WEST SUSSEX COUNTY COUNCIL CONSULTATION

TO:	Arun District Council FAO: Andrew Wood
FROM:	Highways, WSCC
DATE:	26/02/2019
LOCATION:	20 Rife Way, Ferring
SUBJECT:	FG/6/19/PL New Dwelling
DATE OF SITE VISIT:	N/A
RECOMMENDATION:	☒ Advice ☐ Objection ☐ Modification ☐ No Objection ☐ More Information ☐ Refusal
S106 CONTRIBUTION TOTAL:	£N/A

This proposal is for a new 3 bedroom dwelling.

SCALE 1:200 @ A3	DRAWING No. Site Plan
JOB No.

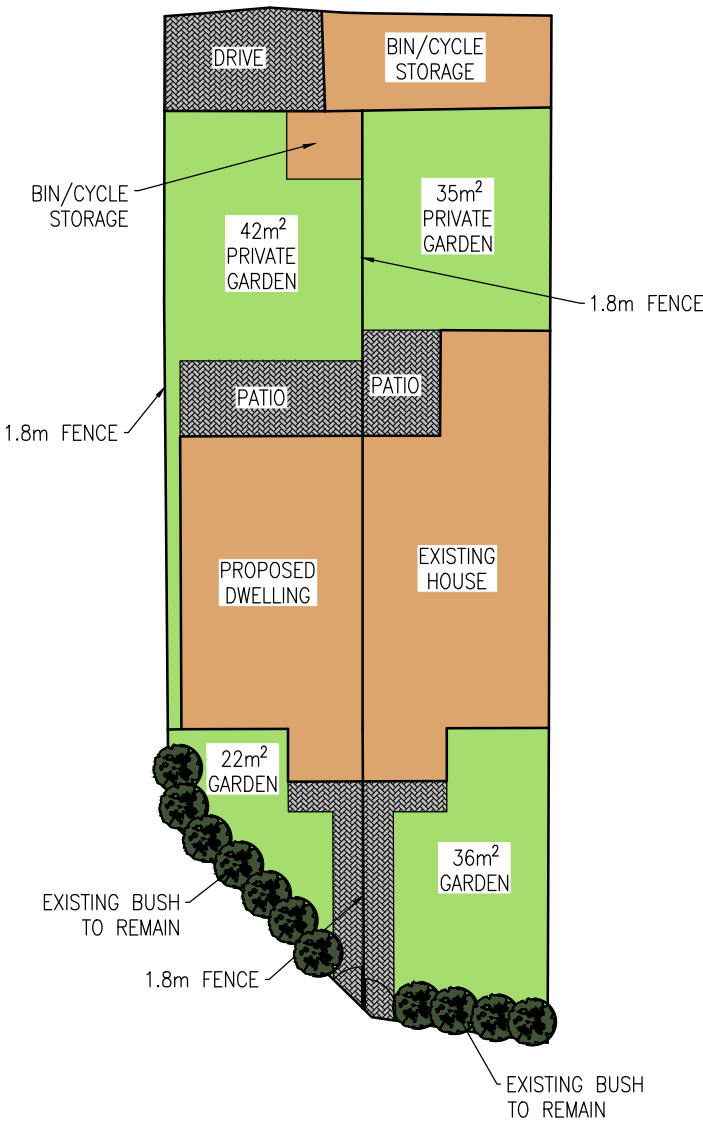
The site is located on Rife Way, an unclassified residential road subject to a 30 mph speed limit. The plans show that no parking spaces or garages are provided; therefore there are no points of access. The existing plots access will remain the same. An inspection of data supplied to WSCC by Sussex Police over a period of the last five years reveals that there have been no recorded injury accidents within the vicinity of the site. Visibility at the Rife Way/St Maurs Way junction will not be affected.

The plans indicate that no off-street parking provision will be provided for the proposed dwelling. Using the WSCC Car Parking Demand Calculator, the size and location of this dwelling determines that at least 1 car parking space is required. Any overspill parking as result of this proposal could be accommodated on-street. We would not consider that highway safety would be detrimentally affected through the proposed nil car parking provision. The Planning Authority may wish to consider the potential impacts of this development on on-street car parking from an amenity point of view.

The property is situated close to Ferring Street which is well connected by bus routes and provides sufficient shops and services that would reduce the need for a car. Furthermore, local schools are close and accessible by bicycle or public transport. Cycling is a viable option within this vicinity. Cycle storage has been demonstrated in the plans, and the dimensions shown allow for at least 2 bicycles to be stored inside.

No part of the development shall be first occupied until covered and secure cycle parking spaces have been provided in accordance with the approved plan.
